## EDMONDSON PARK SOUTH

### RESPONSE TO SUBMISSIONS STAGE 1 PROJECT APPLICATION

1 TYPICAL DETAIL - OPEN SPACE ROAD (MAJOR WITH CYCLEWAY)
Scale: 1:50

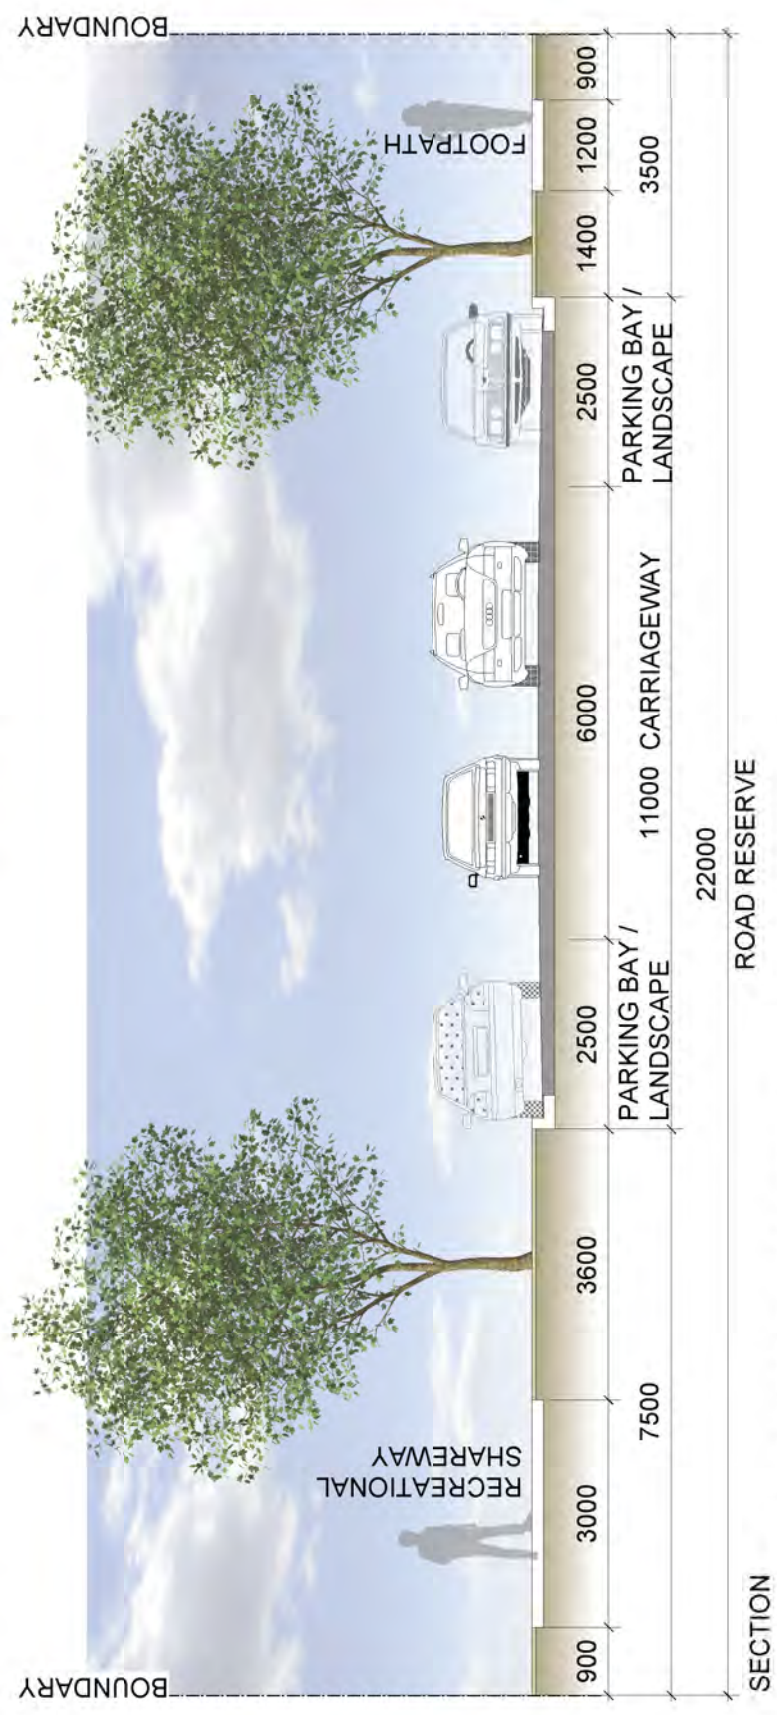
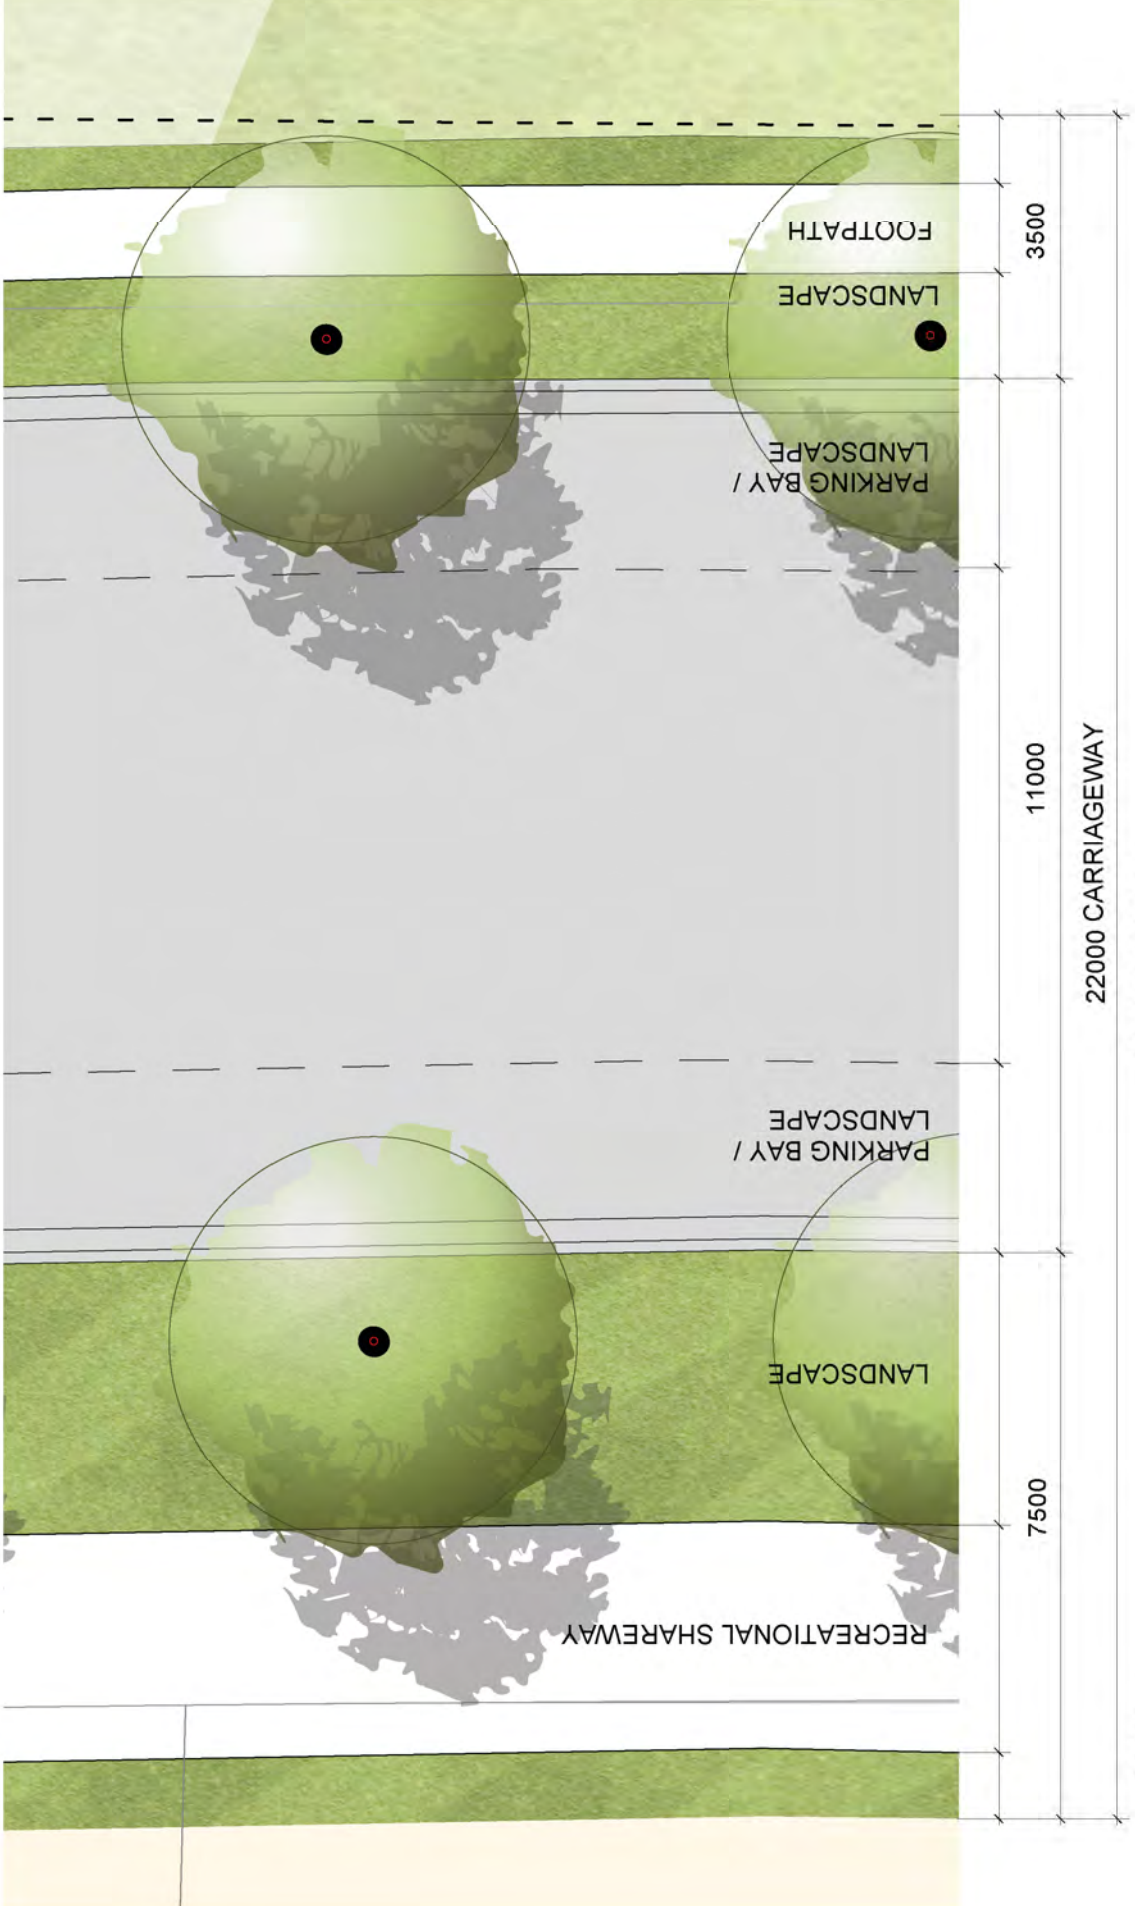
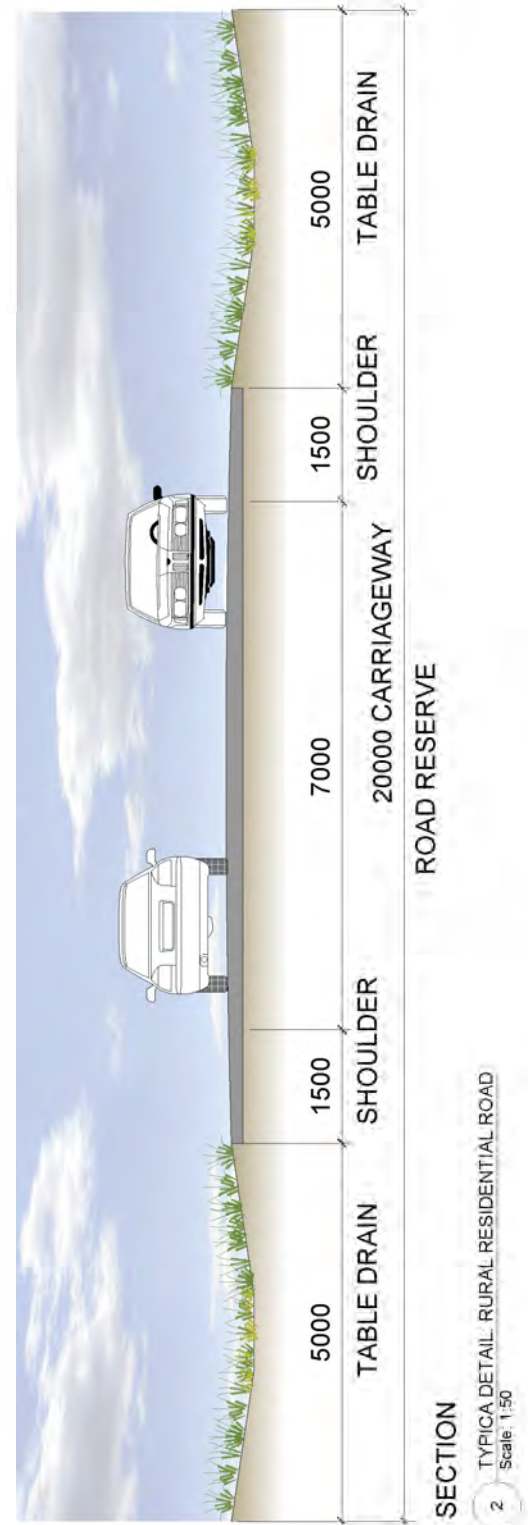
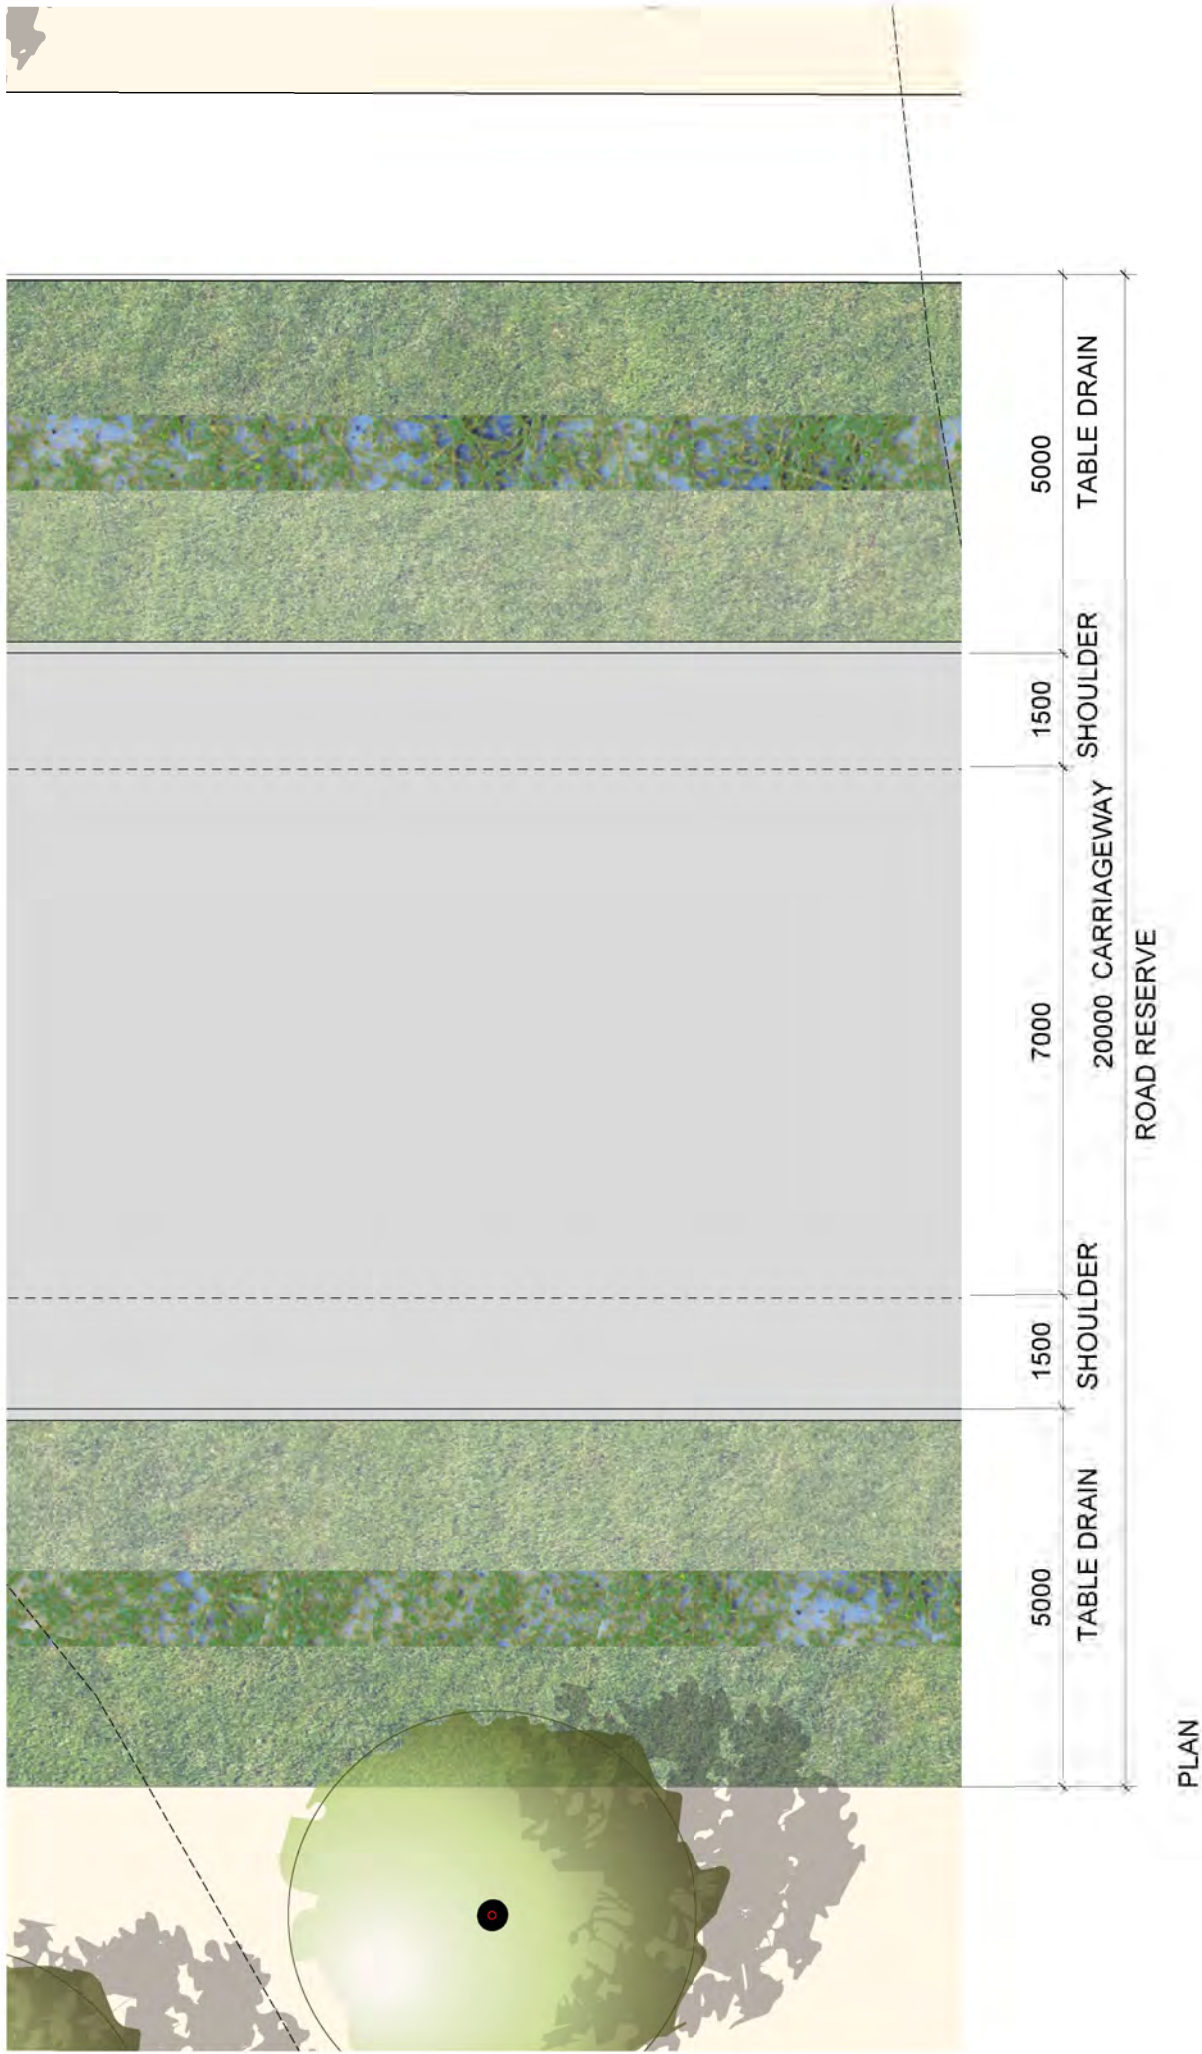
CC 6	<p>In addition to the above, the cycleway for Road 5 is not shown on the Concept / Stage 1 civil works plans. The cycleway is shown on the typical cross sections of the same plans.</p>	<p>Noted. The proposed cycleway for Road 5 will be shown on the Concept / Stage 1 civil works plan. Refer to Statement of Commitment No. 37 of the Concept Plan PPR.</p>

Figure 5-2 Stage 1 Daytime $L_{Aeq(15\text{ hr})}$ 2026 Traffic Noise Levels

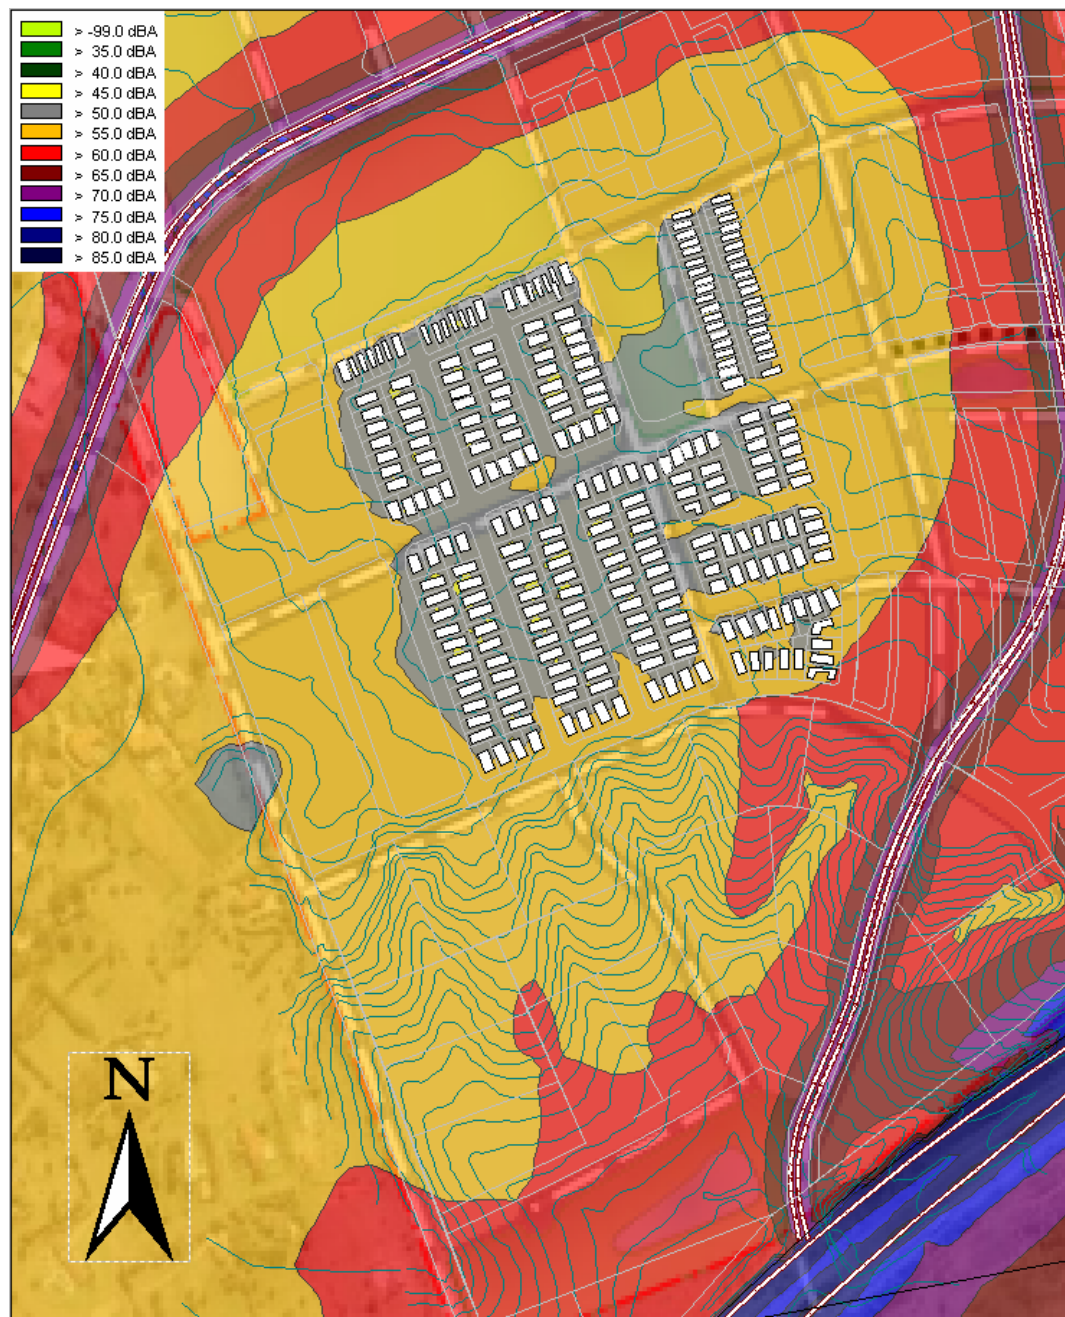
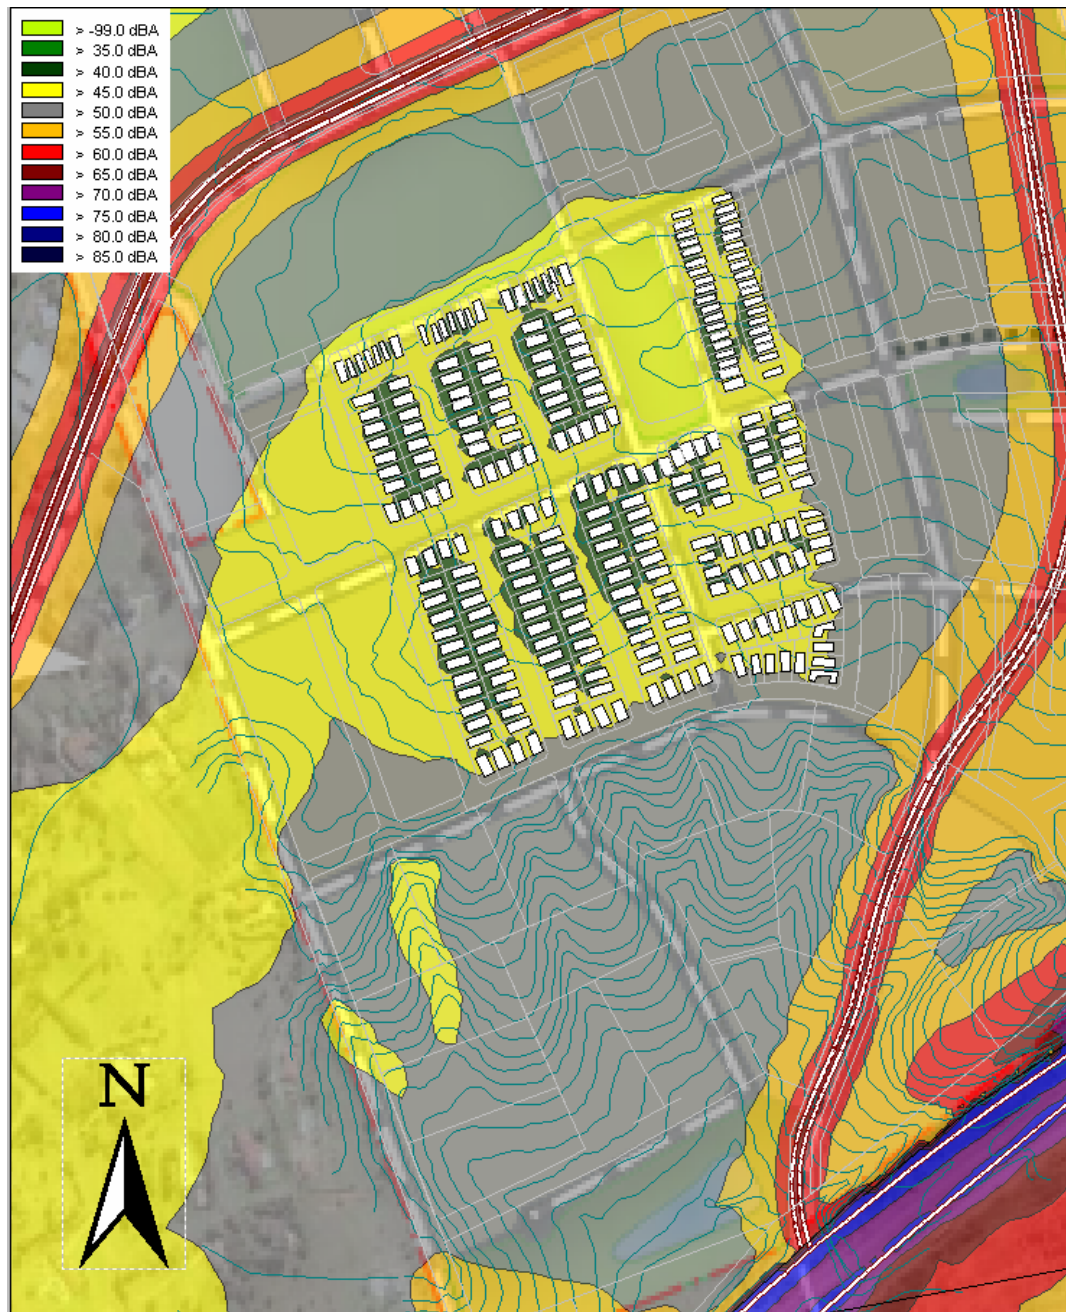
KEY ISSUE / SUBMITTOR	COMMENTS MADE	PROPONENT RESPONSE
DoP 22	<p><b>Noise</b></p> <p>The noise assessment for the concept plan EA should be amended to include an assessment of the impact of increased traffic on existing land uses. Further, the assessment of increased traffic noise at the existing dwellings provided with the project application EA should be amended to specifically identify the expected noise increase at the existing dwellings.</p> <p>Clarification is also sought on the assessment of rail and road traffic noise at residences within the site, as outlined the Concept Plan (section 4.3 of Appendix U). The report states that ventilation is required if the internal noise criteria set out in the <i>Development Near Rail Corridors and Busy Roads - Interim Guideline</i> is exceeded by more than 10dBA, however the proposed criteria for provision of ventilation is 20dBA above the relevant criteria set out in the <i>Development Near Rail Corridors and Busy Roads - Interim Guideline</i>.</p>	<p>A Supplementary Noise Assessment Report has been prepared by Wilkinson Murray and is included at <b>Appendix I</b> of the Concept Plan PPR. The supplementary noise assessment provides an assessment of the impact of increased traffic noise on existing land uses and provides clarification on the assessment of rail and road traffic noise at residences within the site.</p> <p>In relation to traffic noise, a review of predicted noise levels indicates that traffic noise levels at assessed residences along Campbelltown Road will be above the ECRTN noise objectives with or without the development. This being the case the increase in noise levels has been reviewed with respect to the 2 dBA increase objective.</p> <p>In the case of all existing residences to the West of Zouch Road a maximum increase of 0.3 dBA is predicted at residences with the development traffic flows. This is well below the allowable 2 dBA increase and is therefore considered acoustically acceptable.</p> <p>In the case of residences that are to be constructed along Campbelltown Road at Ingleburn Gardens the resulting increase in noise levels associated with the Edmondson Park development is slightly higher (0.2 dBA) than the allowable 2 dBA increase. However, it is noted these residences in the estate have been identified in the assessment of the Ingleburn Gardens site as being potentially affected by traffic noise. Therefore noise mitigation, including a noise wall, has been included in the design of this development to address traffic noise impacts. Therefore the acoustic amenity of these future residences has been addressed in the urban design of the Ingleburn Estate development and therefore the impact of increased traffic on these properties as a result of the concept proposal and project application is considered satisfactory.</p> <p>In relation to rail and road traffic noise at residences within the site, the applicable <u>internal</u> rail and road traffic criteria, set out in the ‘Developments Near Rail Corridors and Busy Roads – Interim Guideline’ has been translated to <u>external</u> noise criteria by allowing a 10 dBA reduction in noise levels from outside to inside (windows open). That is, an internal noise criterion of 35 dBA equates to an external noise levels of 35 dBA plus 10 dBA = 45 dBA. The requirement for ventilation is <sup>24</sup>when noise levels are 10 dBA above this level, therefore an external noise level of 55 dBA would trigger the need for ventilation.</p>
